**RE: Pre-App Ref. RV/2022/ENQ/00041**

Proposal: Demolition of existing agricultural buildings and construction of a single detached dwellinghouse.

**Proposed Elevation A**  
Scale (1:100)

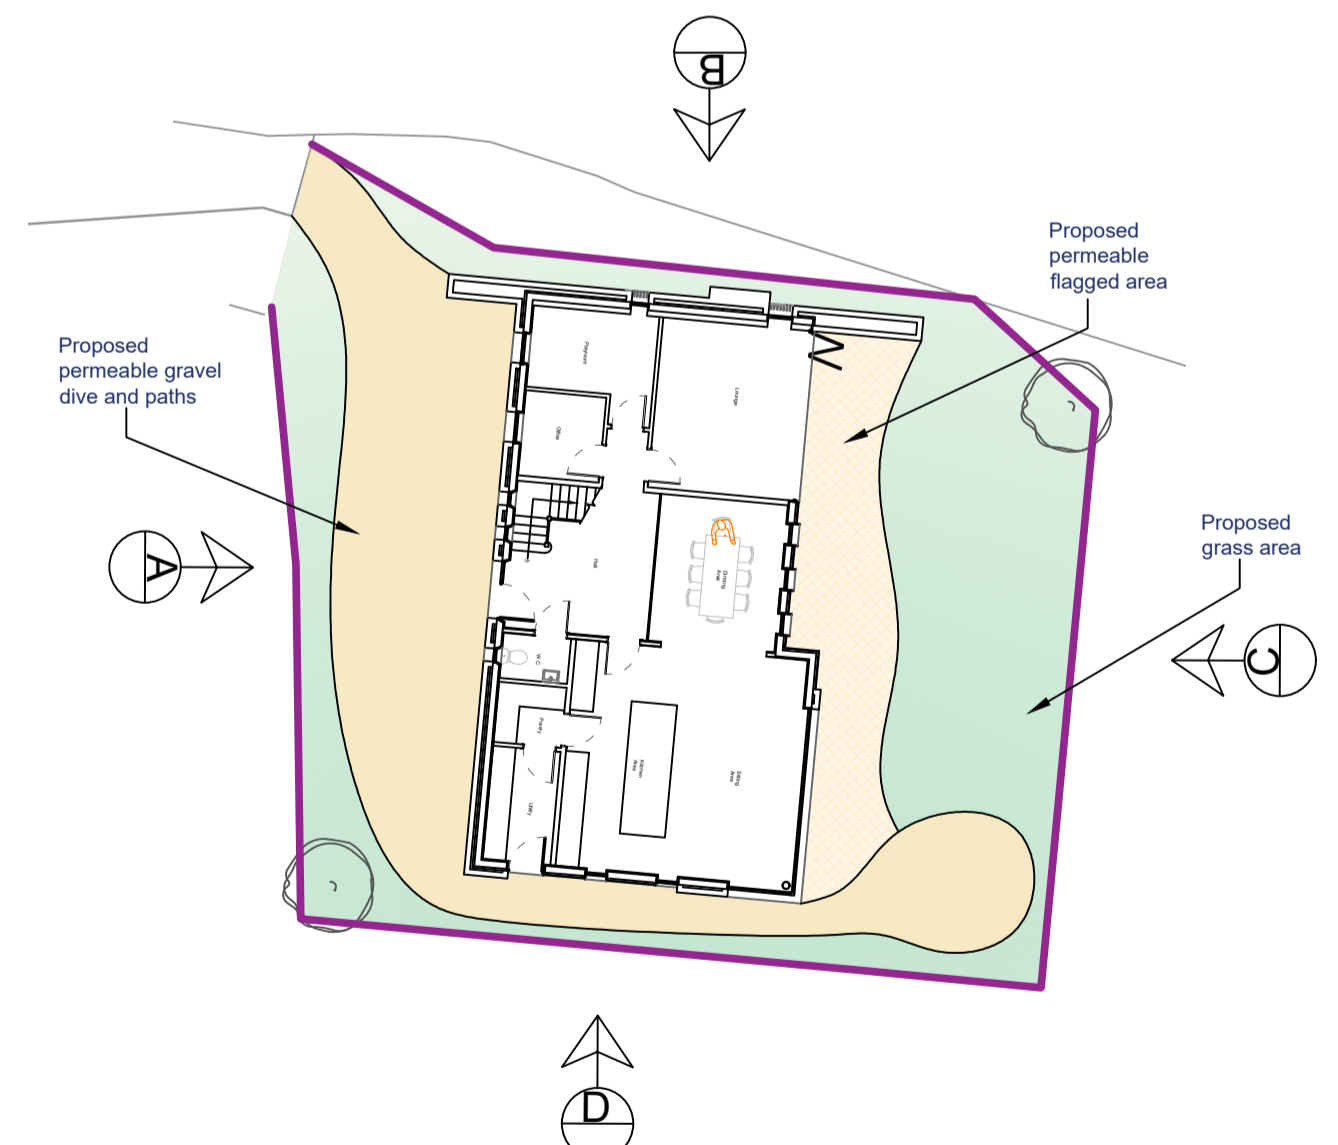
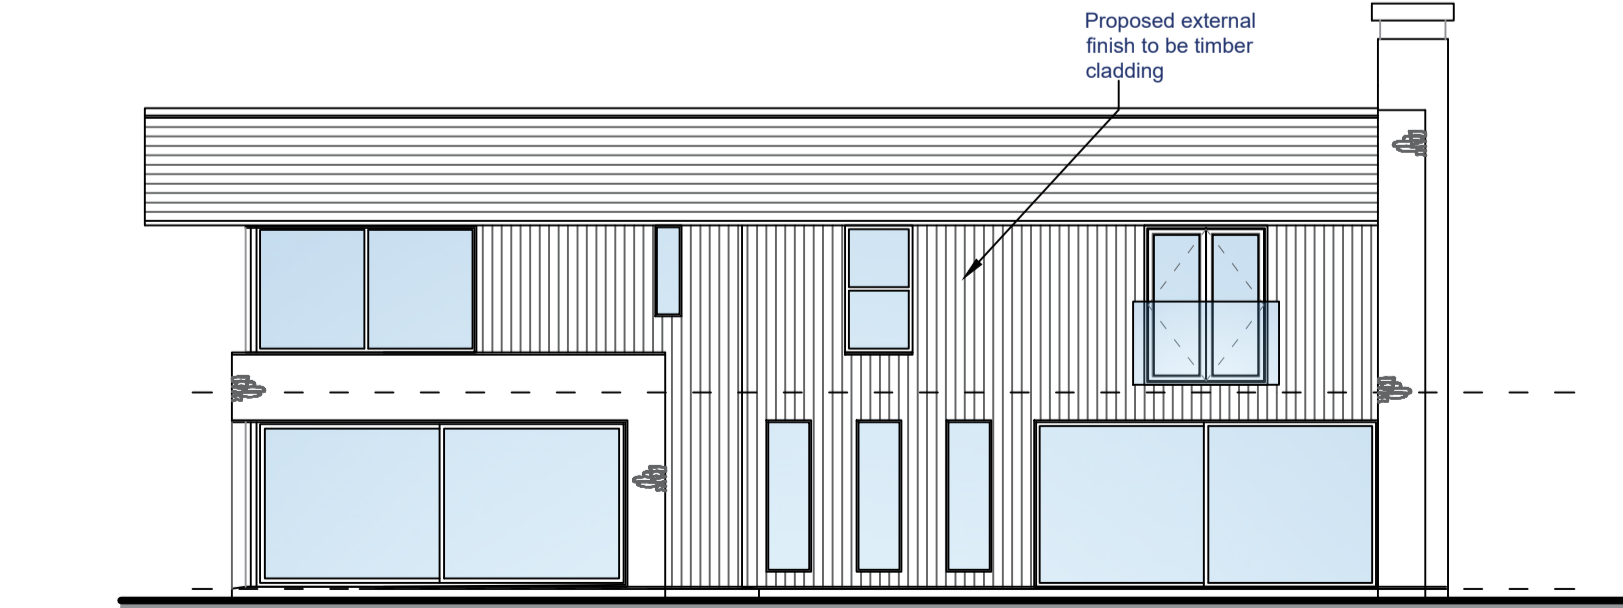
The design appears to seek to replicate a traditional stone-built barn although the resultant development will be a new build dwelling.

The proposed conversion of the agricultural building was found to be acceptable on appeal, however, it is considered that the erection of a new build dwelling on this site would result in more of a suburban nature with large glazed openings to all

elevations which reflect a modern suburban development and replica narrow slit windows and double height cart doors which reflect a traditional stone built barn which this development would not be. This approach introduces a confusing mix of styles, whereas in my view any new development within rural areas should be an honest reflection of the history of the site rather than try and replicate parts of a building that never existed here.
